Form DCPR-4 - TCP COMMENT DISPOSITION FORM

Project: Bridge Boulevard - Phase I

Document Considered: Bridge PH I Reconstruction plans

Review Type: PS&E CABQ comments

Profile Report  
Profile: Profile - 8

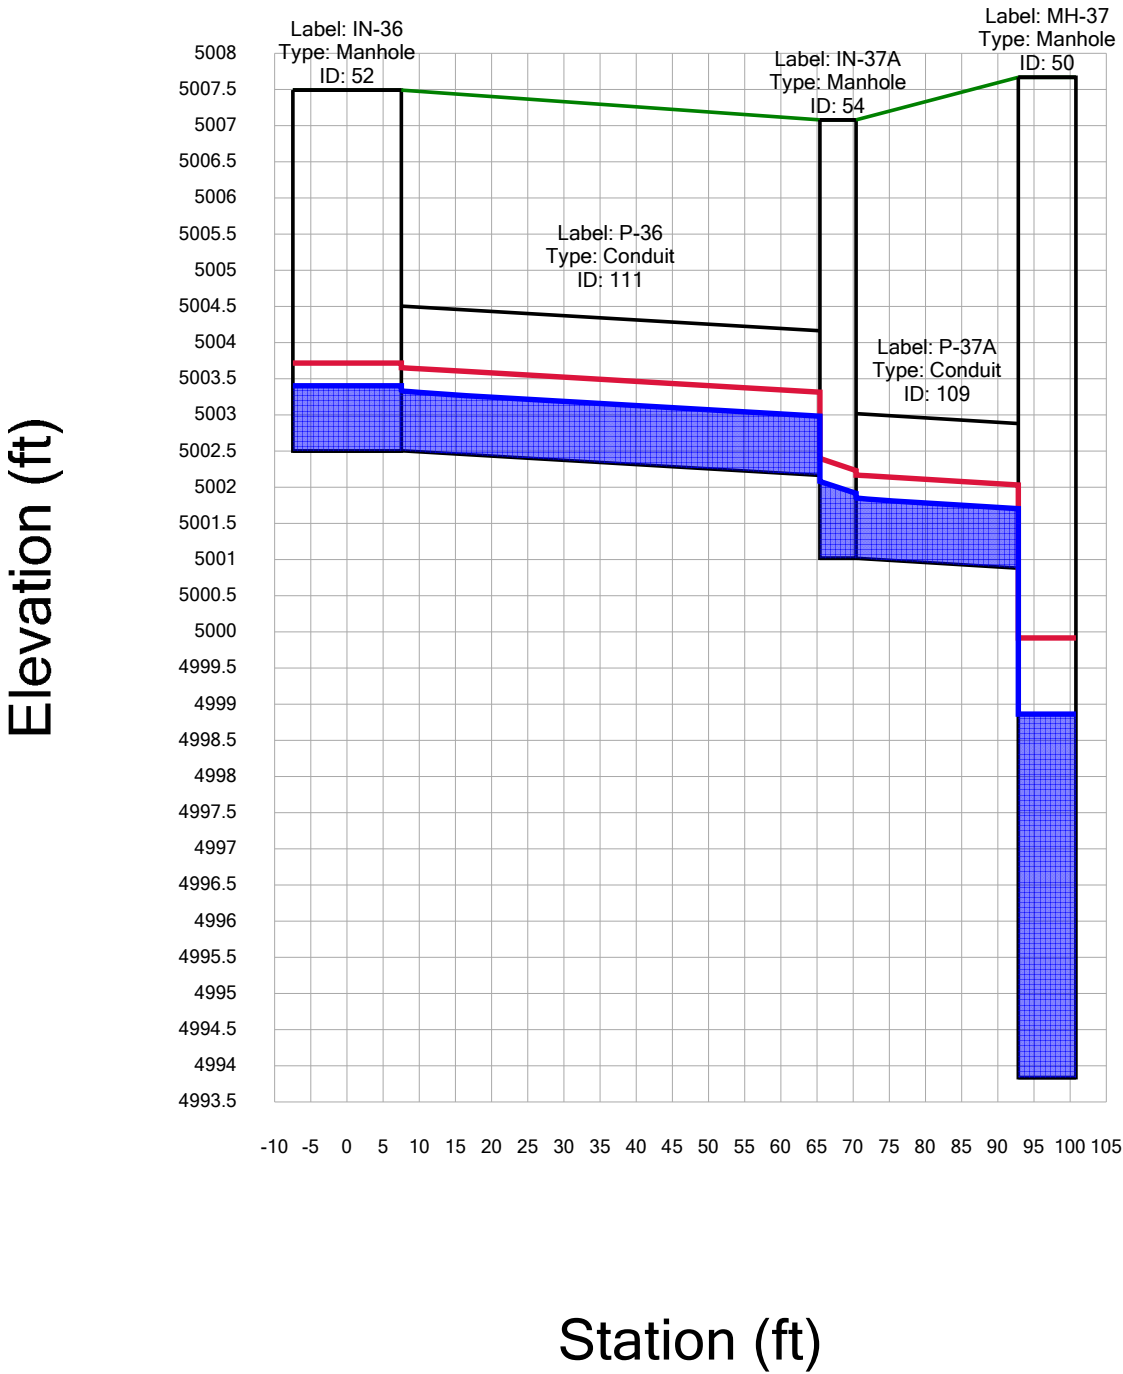
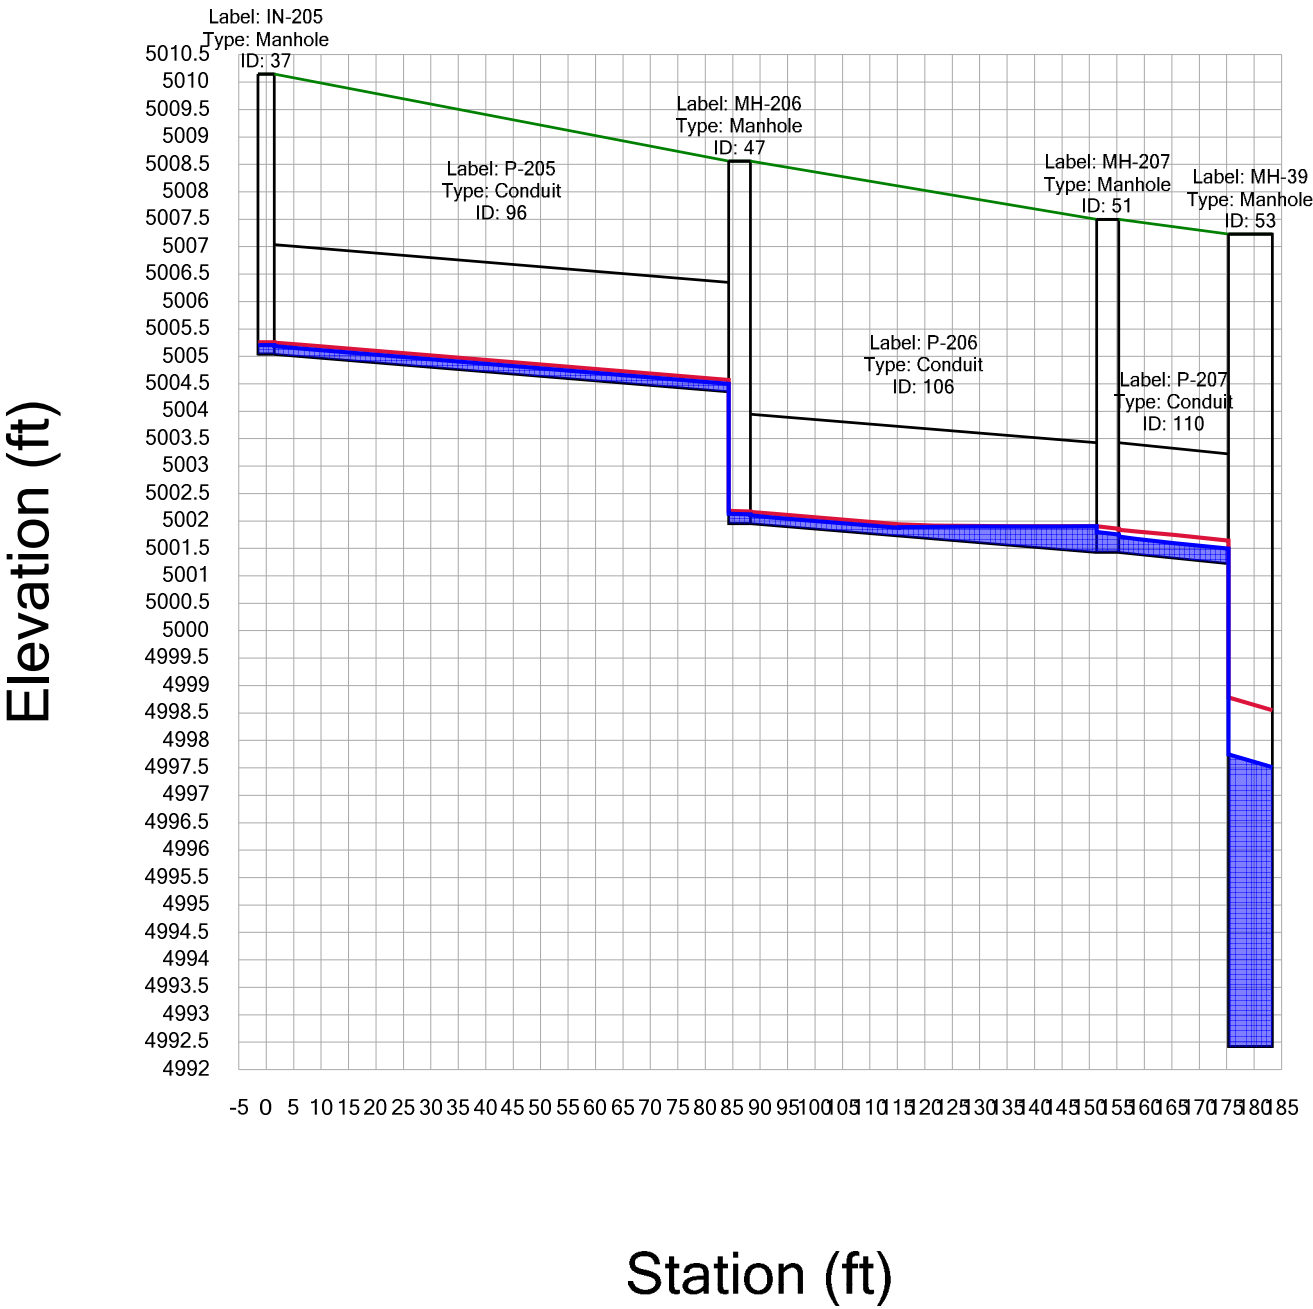
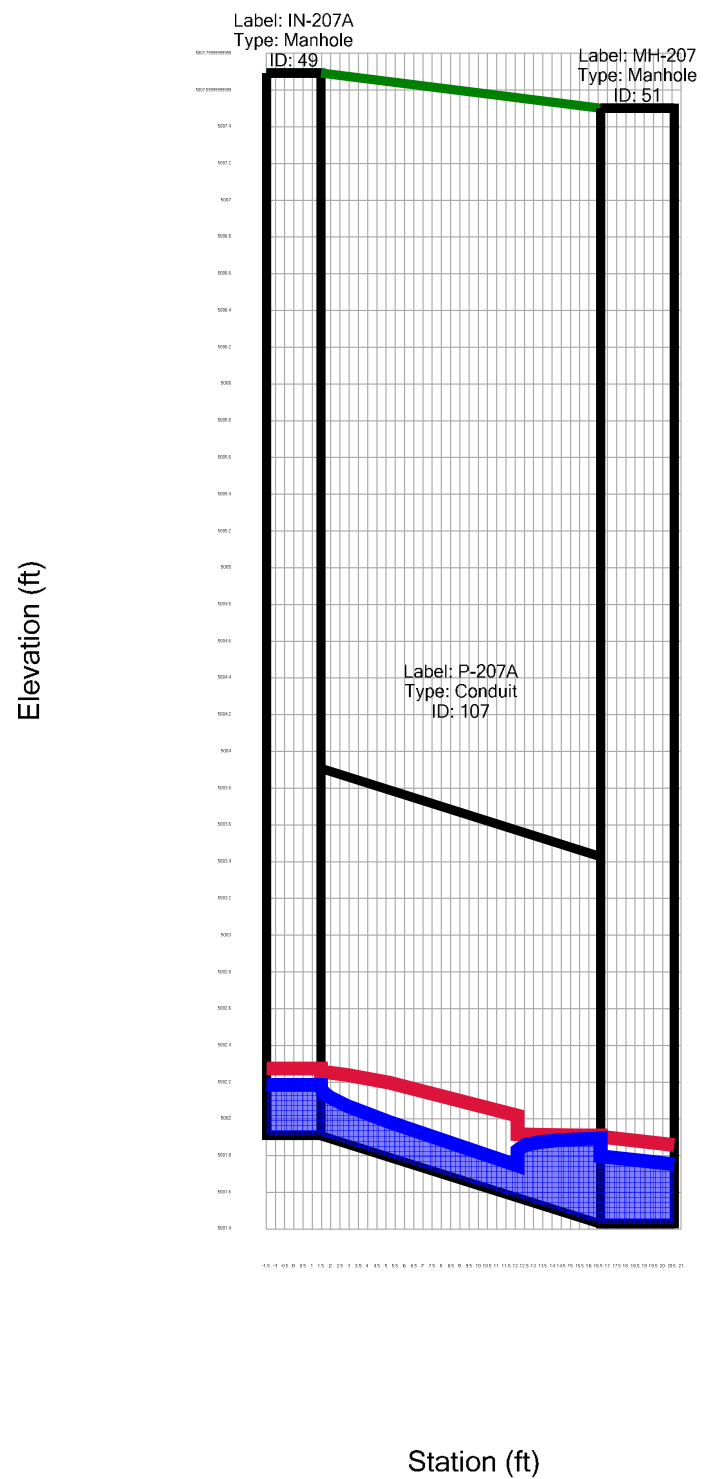
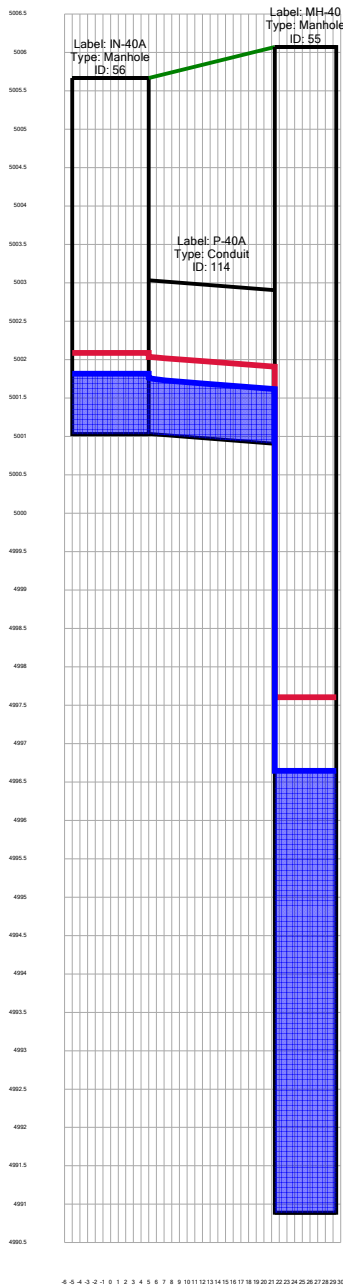
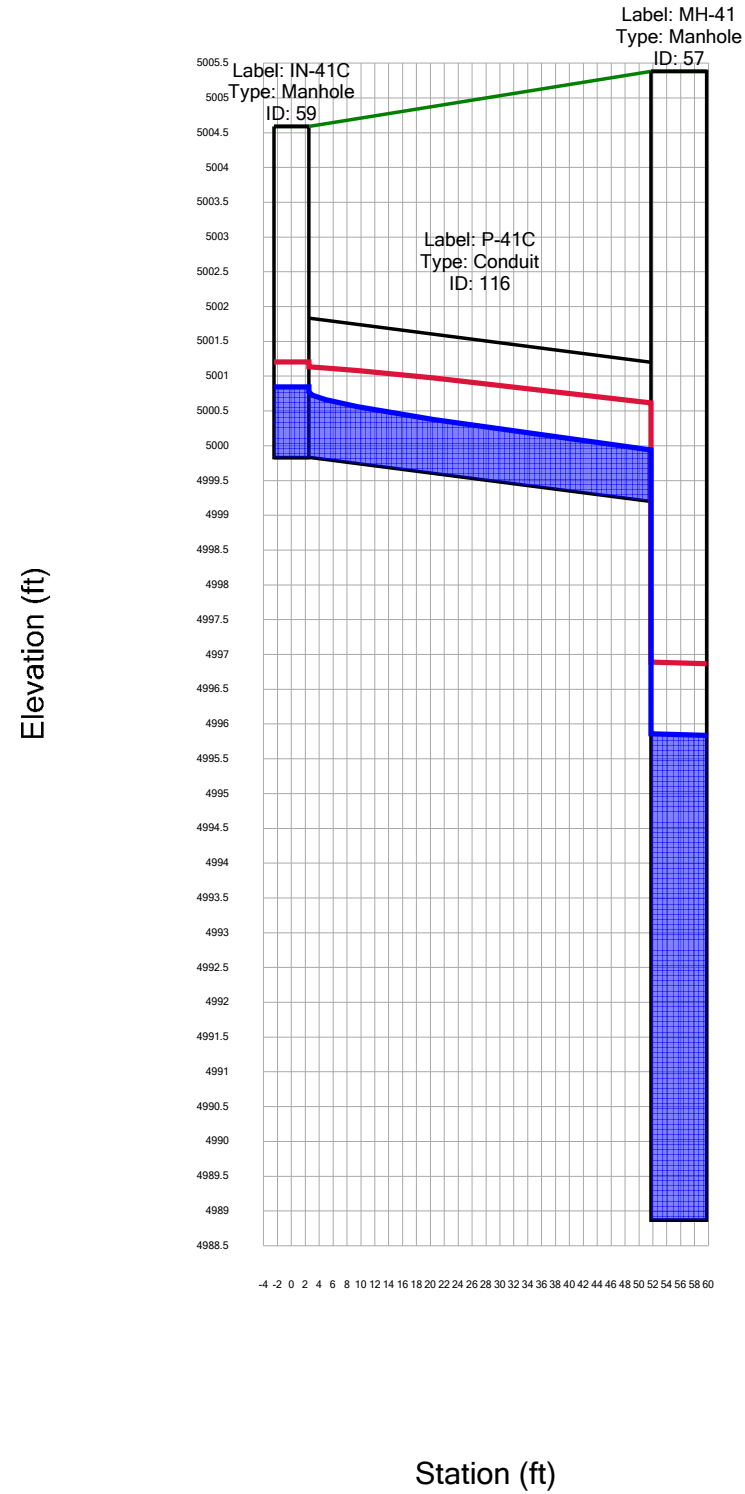
6	Analyse the impact of the new downstream pipes on the existing 36" RCP in Bridge that is to remain. HGL calculations required	HDR can provide a HGL comparison in existing and proposed conditions. However, proposed system is significantly larger than the existing system and HGL is below ground level as required in the criteria manual.
	146	7	The 2nd lane north of the median is dimensioned at 10'. Other lanes are 11'. and typical section shows 11'. Is this intentional?	Revise dimension to 11'
Roadway	N/A	8	A typical section from Station 201+96 to 205+27 is not provided. This is the confusing area with the 19' lane and the turn to Cortez.	See sht. 31 for Slip Lane typical Sections.
	153	9	Upper view: Your match line should refer to sheet 146	Revised matchline to refer to sht. 146 in lieu of 147.
